PORTLAND MAINE

January 23, 2008

RE: 79 City Point Road, Peaks Island – 087 K024 – IR-2 – add second floor bathroom – permit #08-0049

**SECOND FLOOR PLAN
EXISTING CONDITIONS**

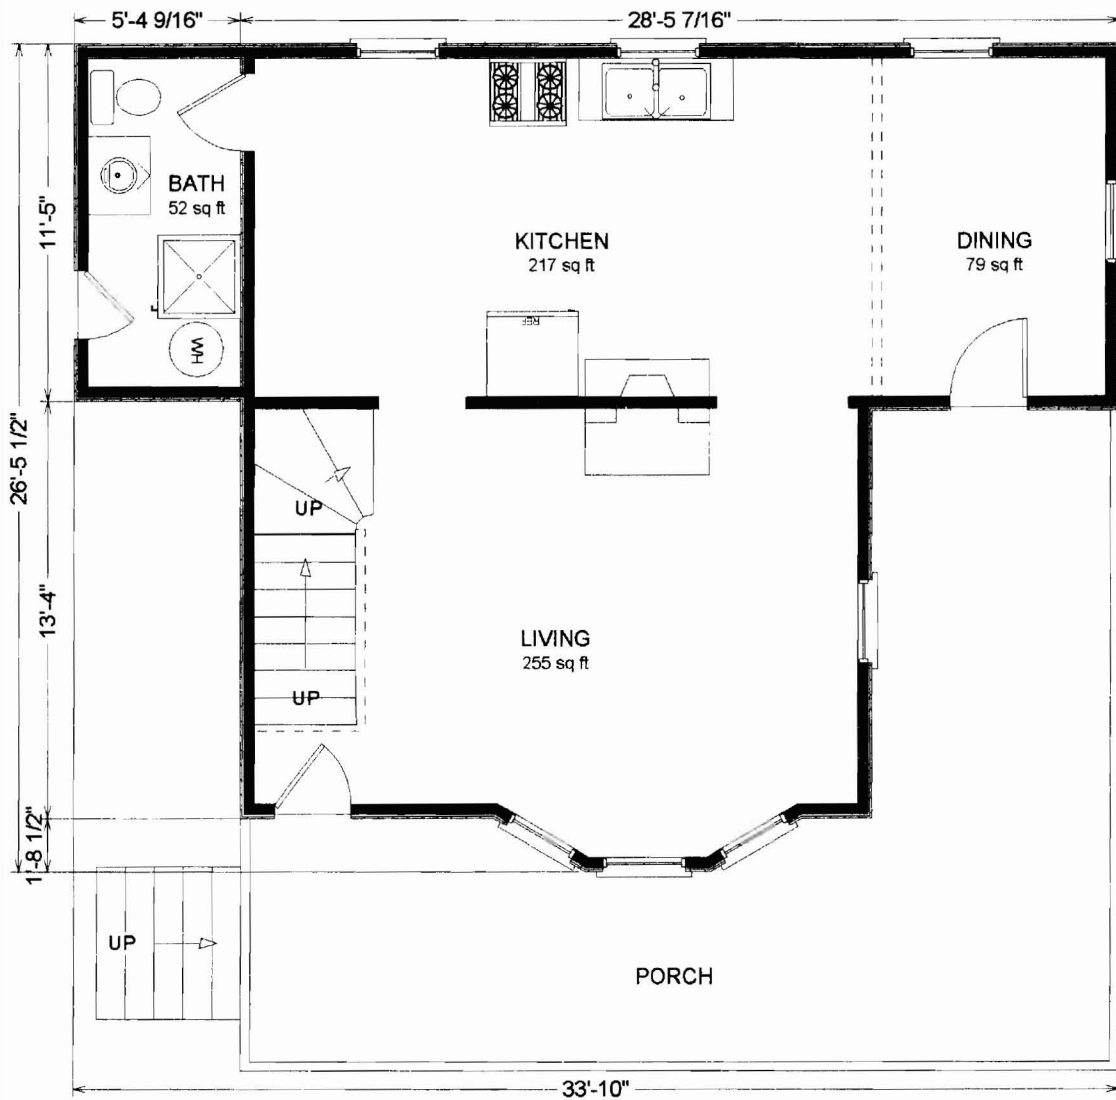
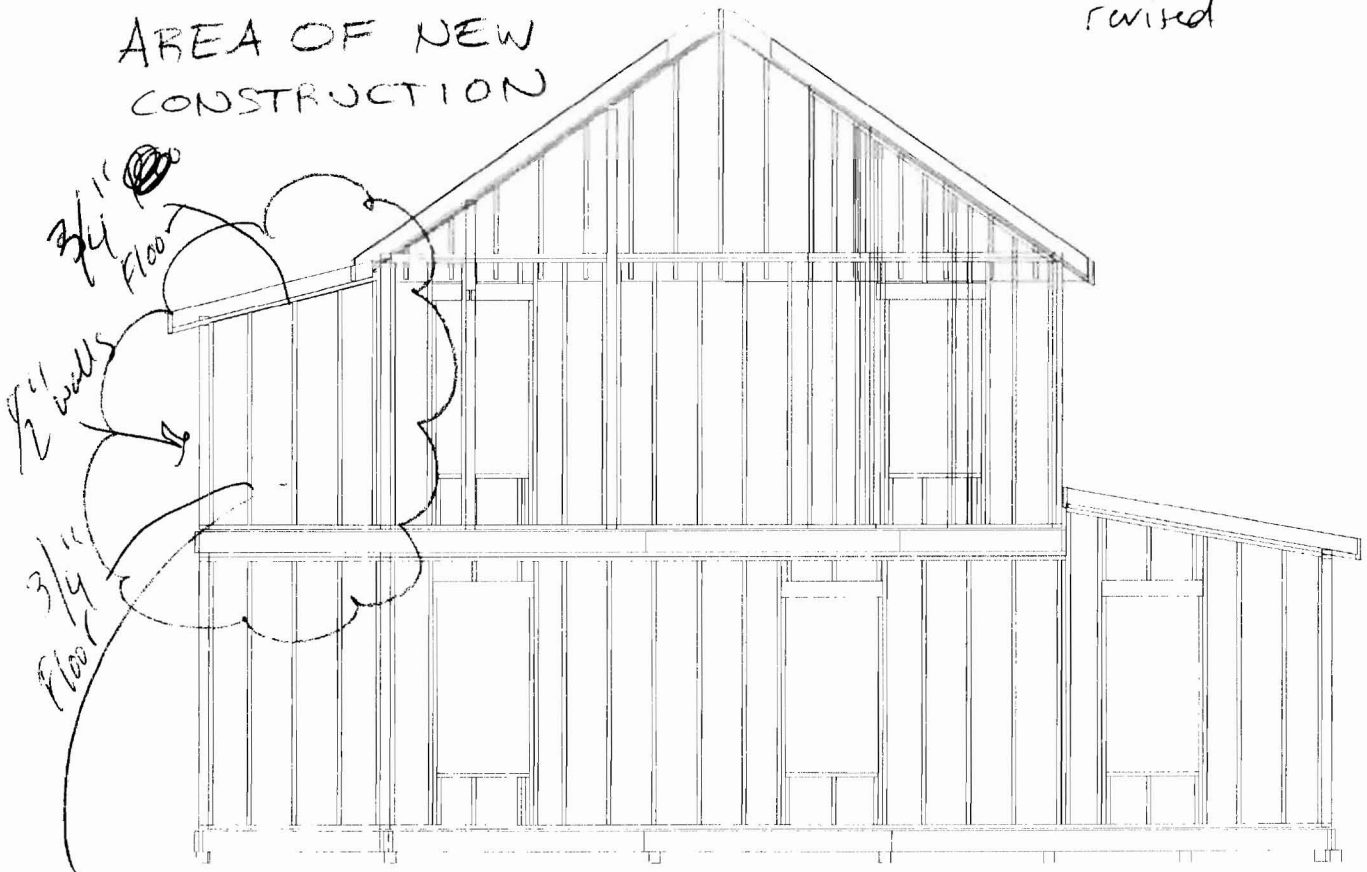
In reviewing your building permit application for 79 City Point Road, Peaks Island, part of the proposed project is to add a second floor bathroom to the cottage by building a second floor over the existing first floor bathroom. 79 City Point Road is located in the IR-2 residential zone. It is an undersized lot, and the existing structure does not meet the required setbacks for the IR-2 zone. Section 14-436(a) does allow a structure to be enlarged within the existing footprint subject to certain criteria. It limits the floor area of the expansion to fifty percent of the first floor footprint. It also specifies “the additional floor area shall be created in the uppermost floor by the use of dormers, turrets or similar structures.” Your proposed second floor bathroom does not fit these criteria. You are proposing to build a whole new story over an existing one-story area. Since you cannot create a whole new story, I must deny your application to build the second floor bathroom.
